**REQUEST**

Current Zoning: I-1 and R-22MF (general industrial and multifamily residential)  
Proposed Zoning: UR-2(CD) (urban residential, conditional)

Approximately 1.1 acres located east of Turner Avenue, west of Bacon Avenue, and south of Rozzelles Ferry Road.

The petition proposes to develop vacant property in the Seversville neighborhood with up to 15 single family attached units at a density of 13 units per acre.

RZ-1.0

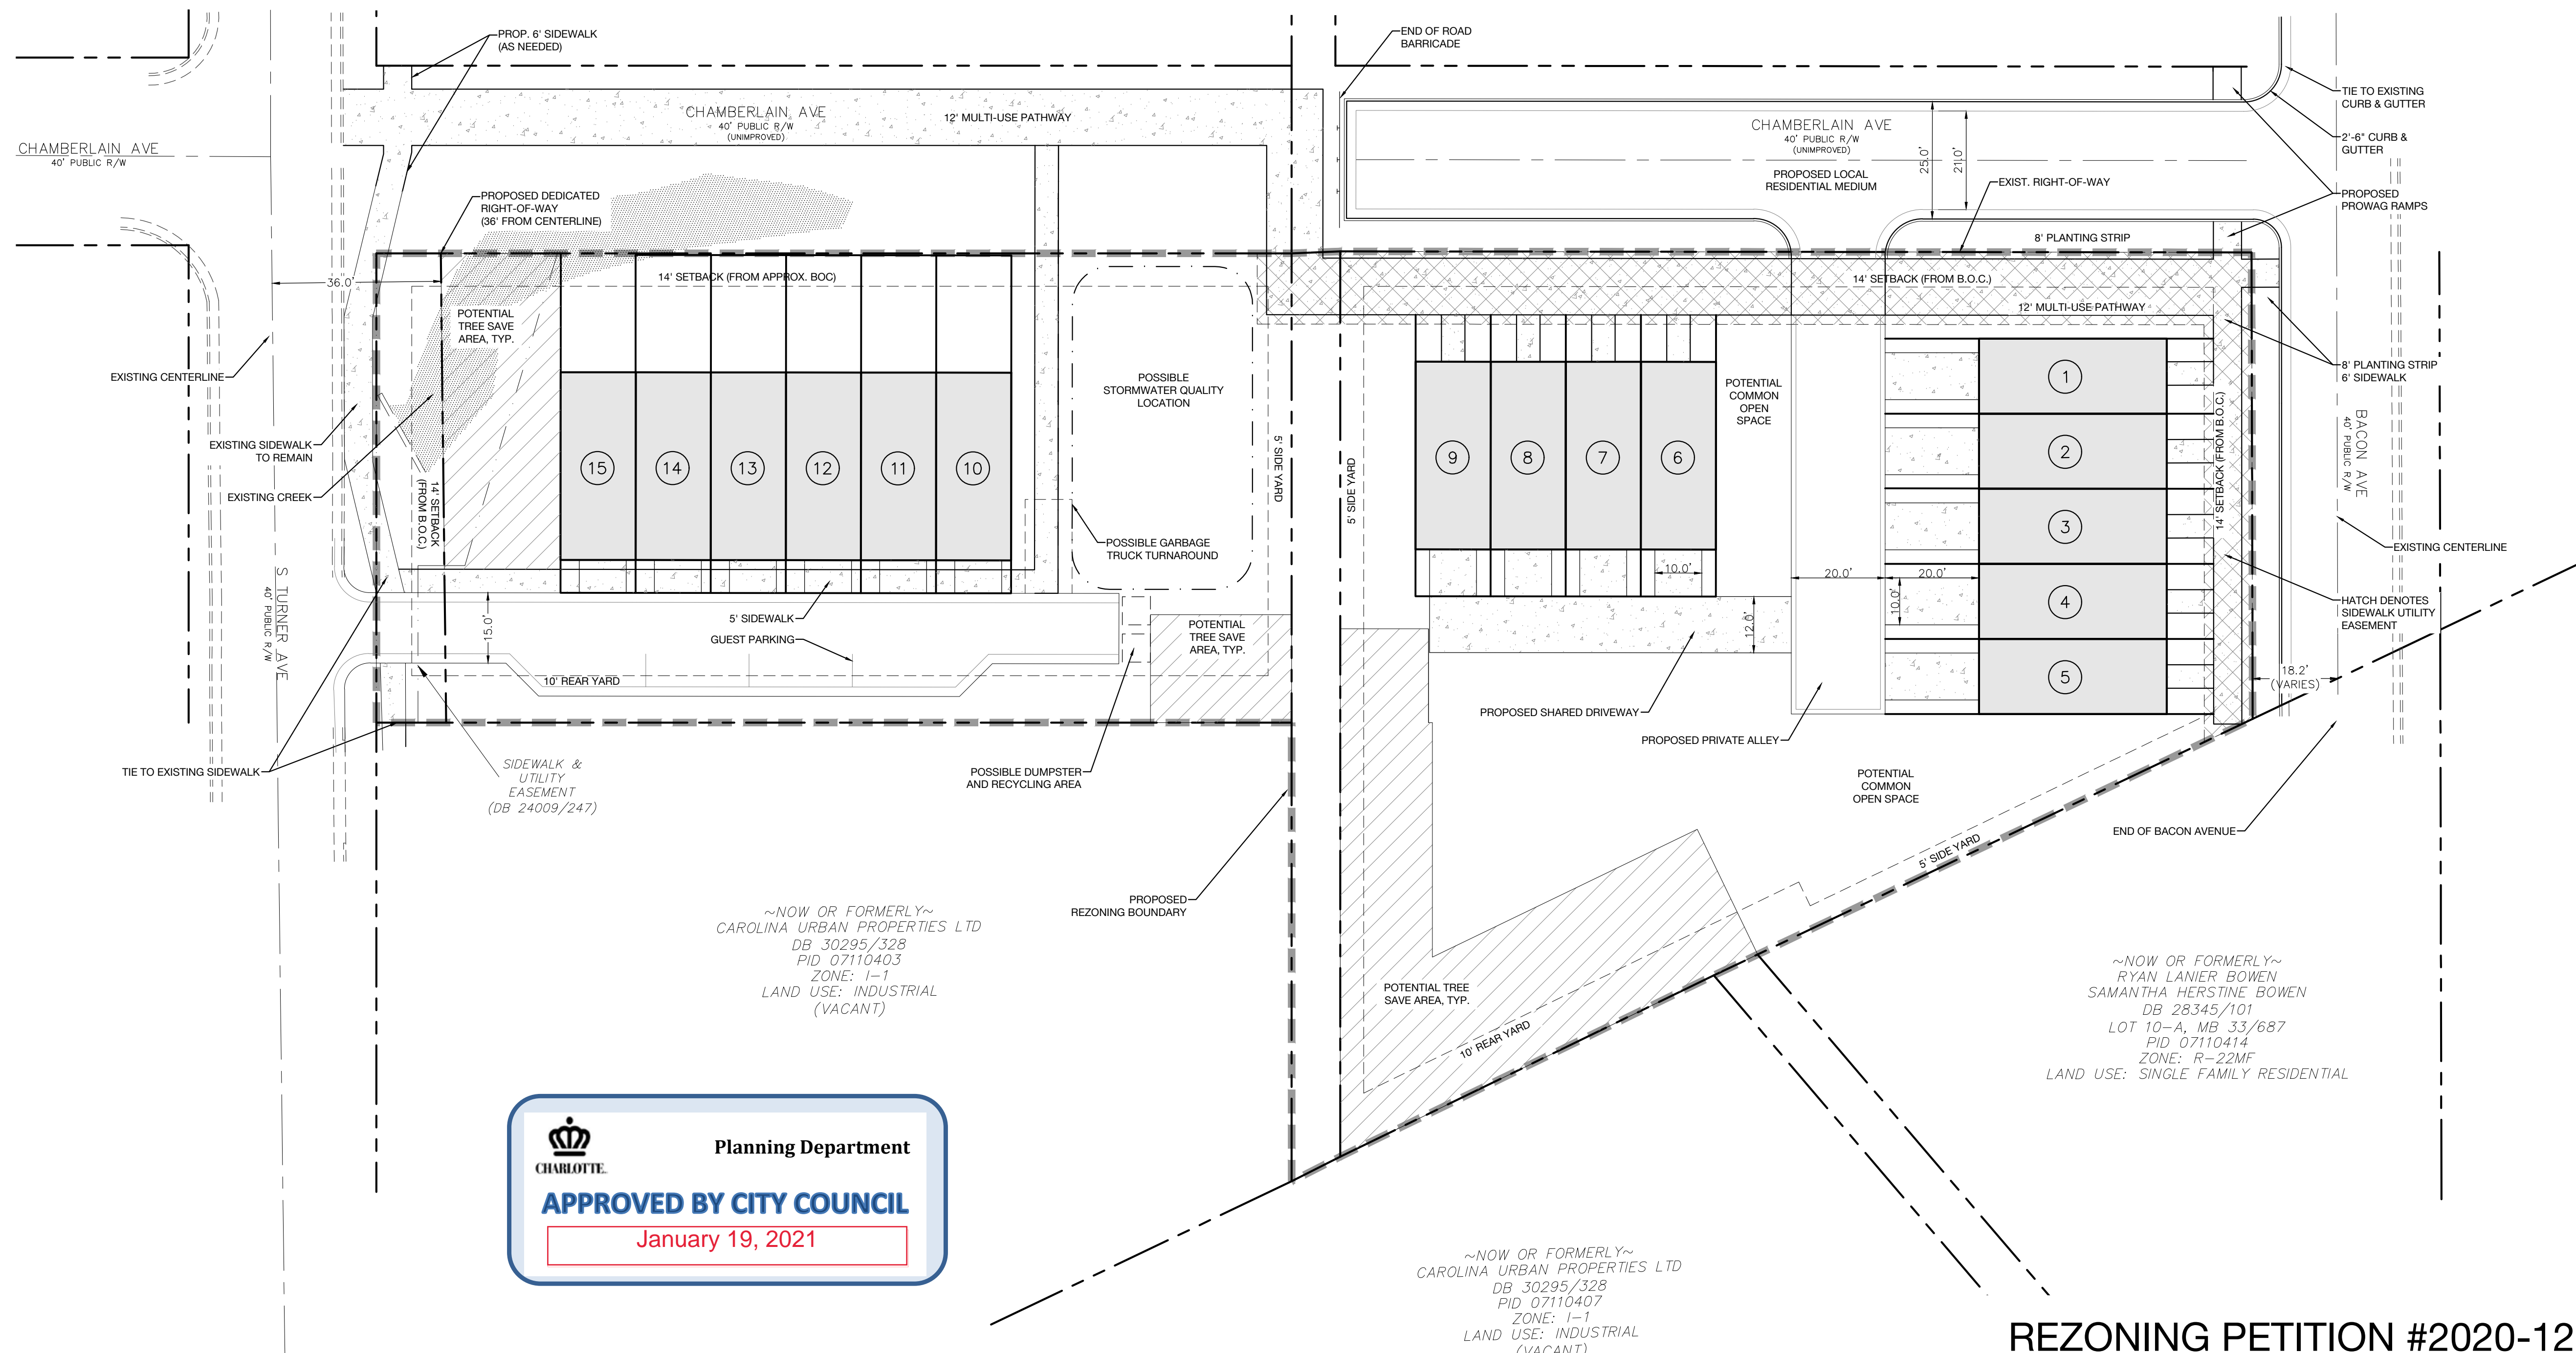
1. ~~Add floor area ratio allowed and proposed to site plan.~~ Addressed
2. ~~Address how trash and recycling will be handled. Trucks cannot back out onto a public street. Either add a turnaround or use smaller dumpsters on wheels that can be rolled to S Turner Avenue for staging on a dumpster pad.~~ Addressed
3. ~~Clarify max building height for structures is capped at 40'.~~ Addressed
4. ~~Clarify that the proposed floor area is the maximum allowed onsite, reword proposed to maximum floor area on the Site Development Data table.~~ Addressed
